# One Earth Solar Farm

**Draft Statement of Common Ground with Newark and  
Sherwood District Council**

**EN010159/APP/8.6.43**

**November-December 2025**

Drawing Number:  
EN010159/APP/6.20/10.1

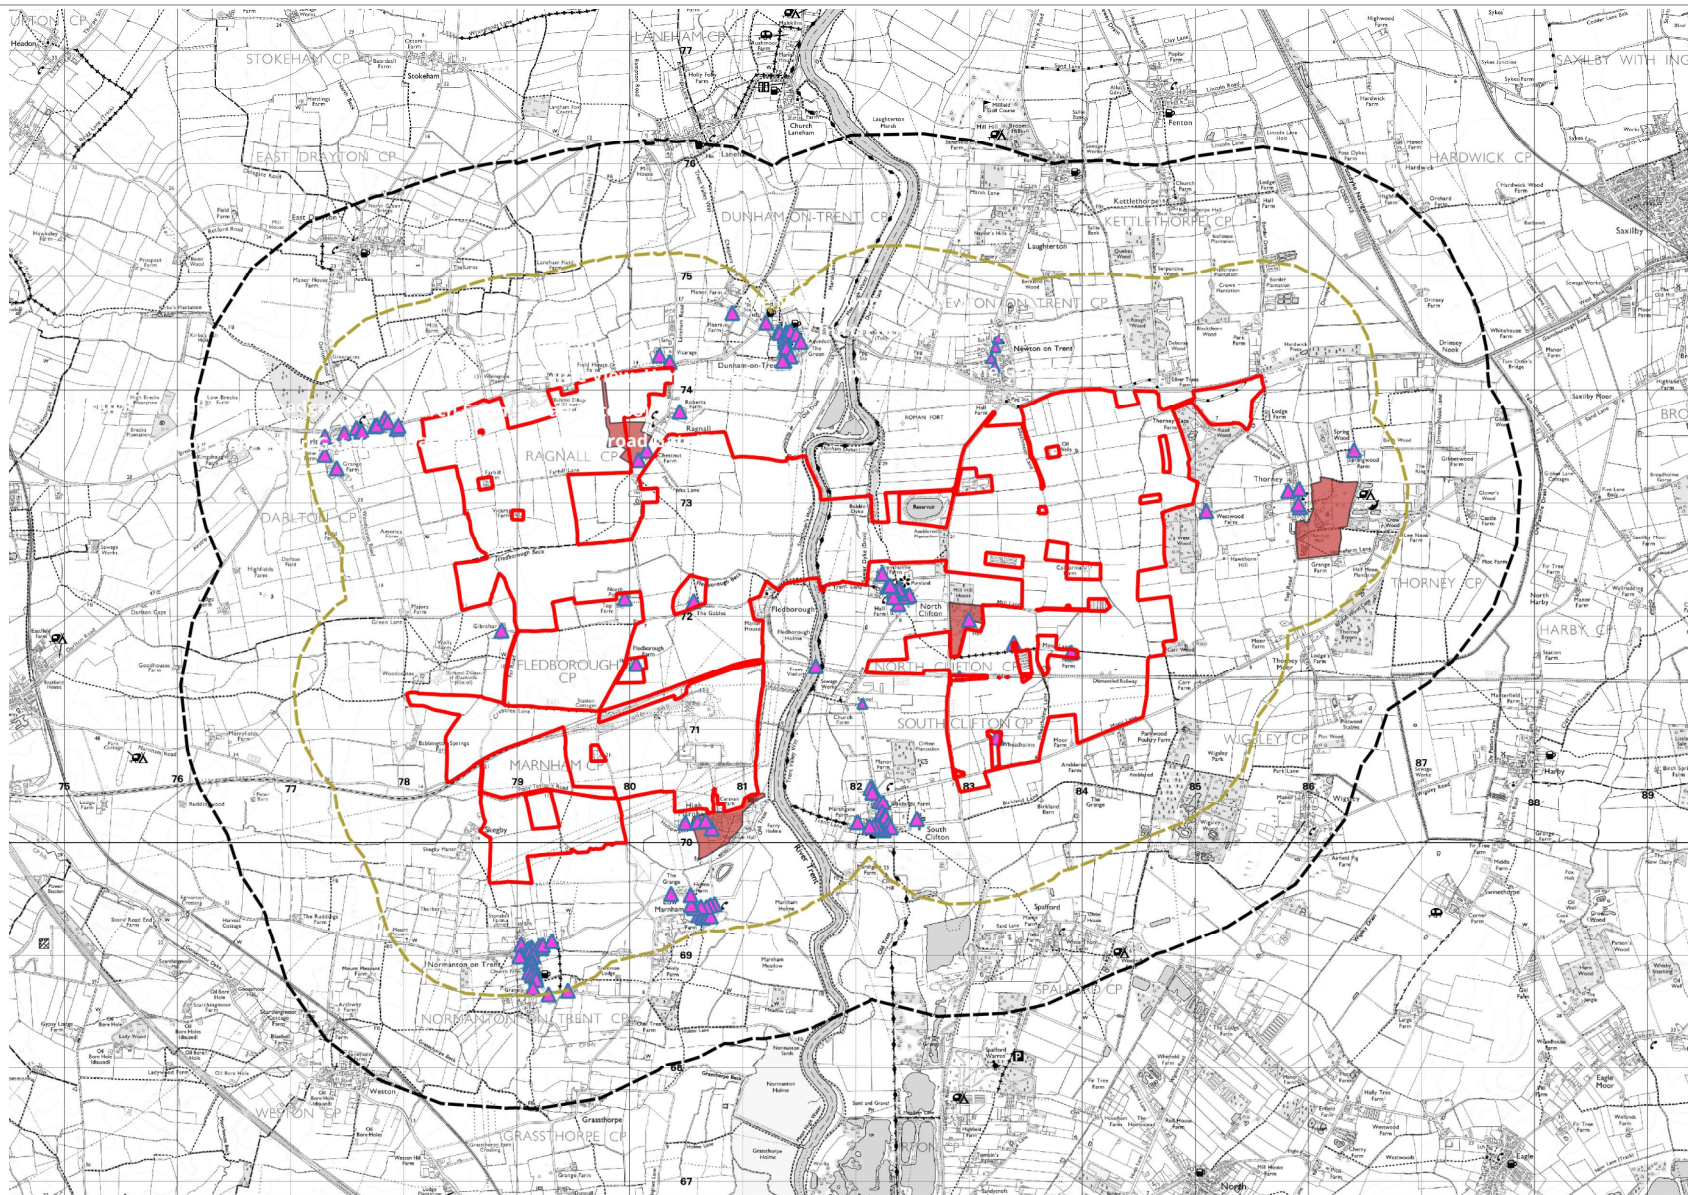
Further detail can be found in the Applicant's Response to Relevant Representations [ REP1-075]	
02-08	Firs Farmhouse (Grade II)	Small strip of the solar farm seems encroach towards the heritage asset	Figure 10.1 [APP-055] of ES Chapter 10 [APP-039] confirms that the Order Limits stand at c.930m to the west of this asset. There is no stretch of the Order Limits which stand within the vicinity of the asset and no harm will arise.  Further detail can be found in the Applicant's Response to Relevant Representations [ REP1-075]	<b>Agreed</b>
02-09	Hall Farmhouse (North Clifton. Grade II, NHLE: 1302529)	There may be possible views from this heritage asset.	As illustrated within Viewpoint 25a (Figure 11.13.7 <sup>a</sup> [APP-068]) and assessed at paragraph 10.6.96 of ES Chapter 10 (ref. APP-039), the Order Limits would stand distant from the asset and hold no intervisibility.	<b>Agreed</b>
02-10	Trent Lane Farmhouse (North Clifton. Grade II, NHLE: 1369937)	There will be views in nearby field. Recommended mitigation suggest increased hedging to the south of the heritage asset.	The Order Limits would stand at distance from the asset (over 280m to the north), would not backdrop views of this asset from the Viaduct, and would hold no adverse effect on the appreciation of the asset as an agriculture farmhouse.	<b>Agreed</b>

<p>No harm is identified and therefore no further mitigation is required.</p> <p>Further detail can be found in the Applicant's Response to Relevant Representations [ REP1-075]</p>	
02-11	The Old Manor House (Thorney. Grade II, NHLE: 1046018)	Mitigation Suggest increased hedging to the south of the heritage asset.	<p>The Proposed Development would not affect the value (significance) of the asset and no further mitigation is required.</p> <p>Further detail can be found in the Applicant's Response to Relevant Representations [ REP1-075]</p>	<b>Agreed</b>
02-12	Thorney War Memorial. (Thorney. Grade II, NHLE: 1462827)	Suggestion to increase hedging to the south of the asset for mitigation.	<p>Figure 10.3 [APP-055] confirms that there would be no intervisibility with the Order Limits. The Proposed Development would not affect the value (significance) of the asset and no further mitigation is required.</p> <p>Further detail can be found in the Applicant's Response to Relevant Representations [ REP1-075]</p>	<b>Agreed</b>

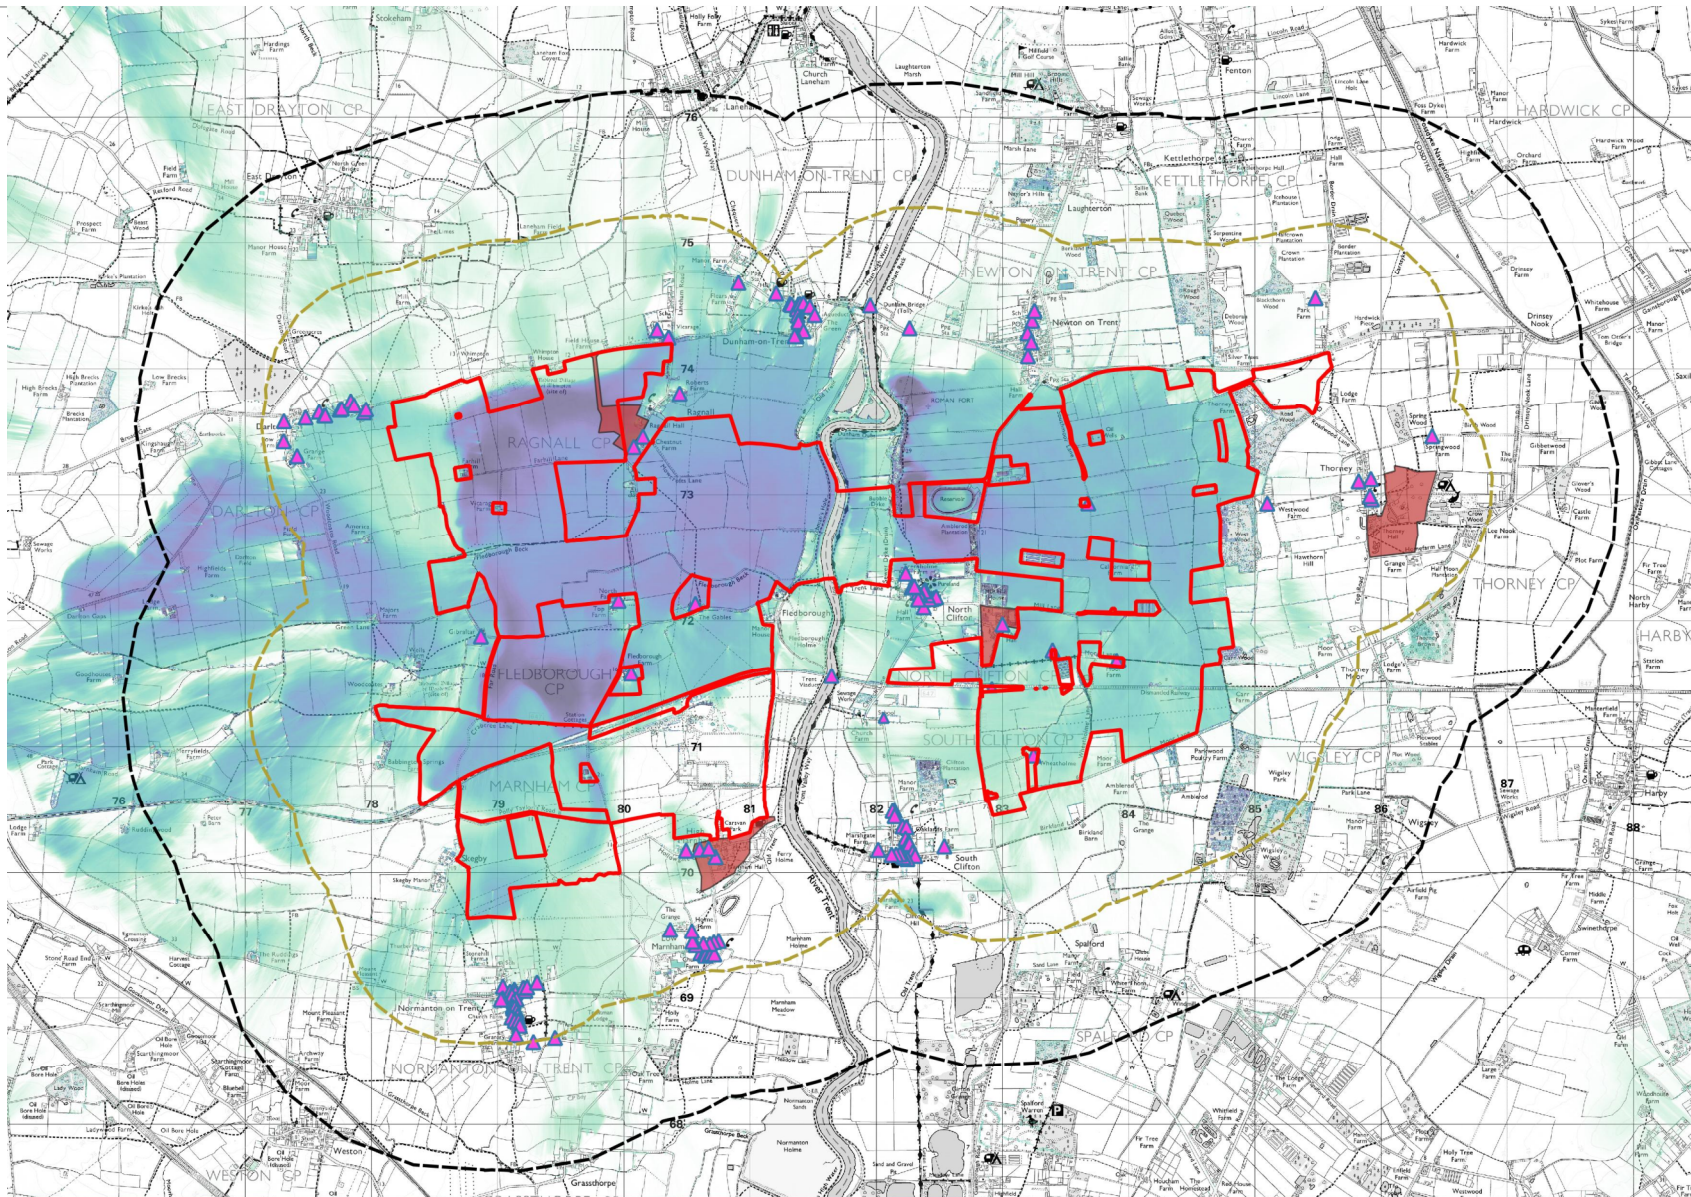
02-04	Perceived impact to Church of St George the Martyr and Church of St Helen	Further consideration required on setting of both assets and further mitigation required – specifically for the impact on Church of St George the Martyr, and Church of St Helen.	<p><u>Church of St George the Martyr</u> Effects of the Proposed Development on St George the Martyr are located within paragraphs 4.136 – 4.139, page 66 of Technical Appendix 10.3 [APP-128] and paragraphs 10.9.9 and 10.6.98.100 of ES Chapter 10 [APP-039].</p> <p><u>St Helen Church</u> This asset has been assessed in ES Chapter 10 (ref. APP-039) at paragraphs 10.6.7 and</p>	Agreed

02-06	Lychgate at Church of St George	“Impact of proposal This listing would not be as impacted as the Church of St George due to its location, but it still forms part of the wider setting.... Recommended Mitigation None would be required for this heritage asset.”	<p>The Zone of Theoretical visibility (Figure 10.3 [APP-055]) confirms no intervisibility of the Proposed Development. There would be no effect on the appreciation of the church, churchyard and lychgate</p> <p>Therefore, this asset would not change the assessed effects (or lack thereof) on the Church of St George the Martyr (Grade II*).</p> <p>Further detail can be found in the Applicant’s Response to Relevant Representations [ REP1-075]</p>	Agreed
02-07	Fledborough Viaduct	The impact of solar panels either side would be detrimental to the wider setting of the viaduct.	<p>No solar arrays are to be located on either side of the viaduct as the land is not included within the Order Limits. It is unclear which northern small parcel is recommended for removal; to clarify the nearest Order Limit north of the Site is at c.660m.</p> <p>As noted within paragraphs 10.6.68 – 10.6.71 of ES Chapter 10 [APP-039], the industrial historic interest of the asset is not reliant on views of a particular character of the landscape to understand its value.</p> <p>The Proposed Development would hold a negligible neutral effect and result in no change to the contribution of the wider setting to asset’s value.</p>	Agreed

02-13	Cottage at Thorney Hall (Thorney.	Suggestion to increase hedging to the south of the asset for mitigation.	Figure 10.3 [APP-055] confirms that there would be no intervisibility with the Order Limits. The Proposed Development would not affect the value (significance) of	<b>Agreed</b>

<p>10.6.126, in paragraph 4.191 of the Technical Appendix [APP-128].</p> <p>The Zone of Theoretical Visibility mapping [Figure 10.3 (APP-055)], the Proposed Development would hold no visibility.</p> <p>Further detail can be found in the Applicant's Response to Relevant Representations [REP1-075]</p>	
02-05	Ruins of Old Church in Churchyard	Recommendation of further mitigation to protect any views.	<p>This asset has been assessed in ES Chapter 10 (ref. APP-039) at paragraphs 10.6.7 and 10.6.126 and on page 85 of Appendix 10.2 (grouped with other assets in Thorney, as agreed with stakeholders – see Table 10.5 [APP-128]).</p> <p>The Zone of Theoretical Visibility, there would be no impact to the value (significance) of this asset, further mitigation is not required as no harm can feasibly exist which requires screening.</p> <p>Further detail can be found in the Applicant's Response to Relevant Representations [REP1-075]</p>	<b>Agreed</b>

Grade II, NHLE: 1369961)		<p>the asset and no further mitigation is required.</p> <p>Further detail can be found in the Applicant's Response to Relevant Representations [ REP1-075]</p>	
02-14	House at Thorney Hall. (Thorney. Grade II, NHLE: 1046017)	Suggestion to increase hedging to the south of the asset for mitigation.	<p>Figure 10.3 [APP-055] confirms that there would be no intervisibility with the Order Limits. The Proposed Development would not affect the value (significance) of the asset and no further mitigation is required.</p> <p>Further detail can be found in the Applicant's Response to Relevant Representations [ REP1-075]</p>	<b>Agreed</b>
02-15	Summary of response	Request for further information on the impacts to the Church of St George the Martyr, and Fledborough Viaduct.	<p>Further information provided to support the assessment that the Proposed Development would not be seen in views of St George the Martyr from the Viaduct.</p> <p>Confirmation of where the assets mentioned have been assessed within ES Chapter 10 [APP-039] and accompanying appendices has been provided to demonstrate that there would be no harmful effects to any of these assets and, as such, no further mitigation is required.</p>	<b>Agreed</b>
